Re: Restaurant with Drive Thru
700 Coors Blvd NW, Albuquerque NM 87105
Traffic Circulation Layout
Architect's Stamp 04-23-2020 (J11-D039)

Based upon the information provided in your submittal received 04-24-2020, the above referenced plan cannot be approved for Building Permit until the following comments are addressed:

Drawing No. C6.1

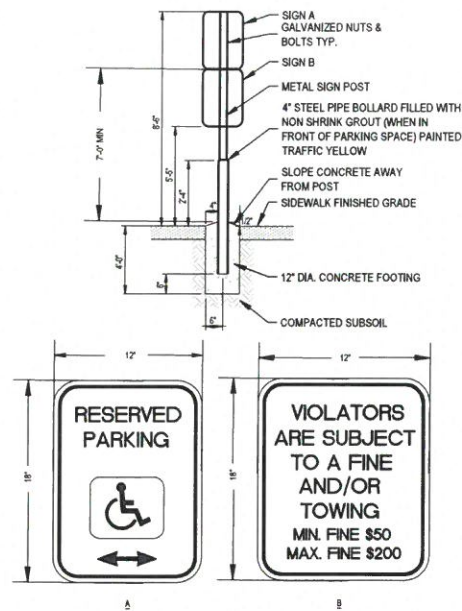
1. Please coordinate with Peter Kubiak (NMDOT Representative) prior to Traffic Circulation Layout approval. This is a condition required for approval.
2. The minimum parking stall dimensions are, not all dimensions are shown:

3. ADA ramps across drive thru lane, and ADA access aisle detail must be provided. No detail has been provided.
4. Motorcycle parking spaces shall be designated by its own conspicuously posted upright sign, either free-standing or wall mounted per the zoning code. The stall dimension are 4 ft min. width by 8 ft min. length. Label pavement MC. There are no motorcycle parking stalls shown on plans, please shown stalls on plans.
5. Provide a copy of refuse approval.

8. Please add a note on the plan stating "All improvements located in the Right of Way must be included on the work order."
9. Existing sign face detail for keyes note 5 needs to be provided.
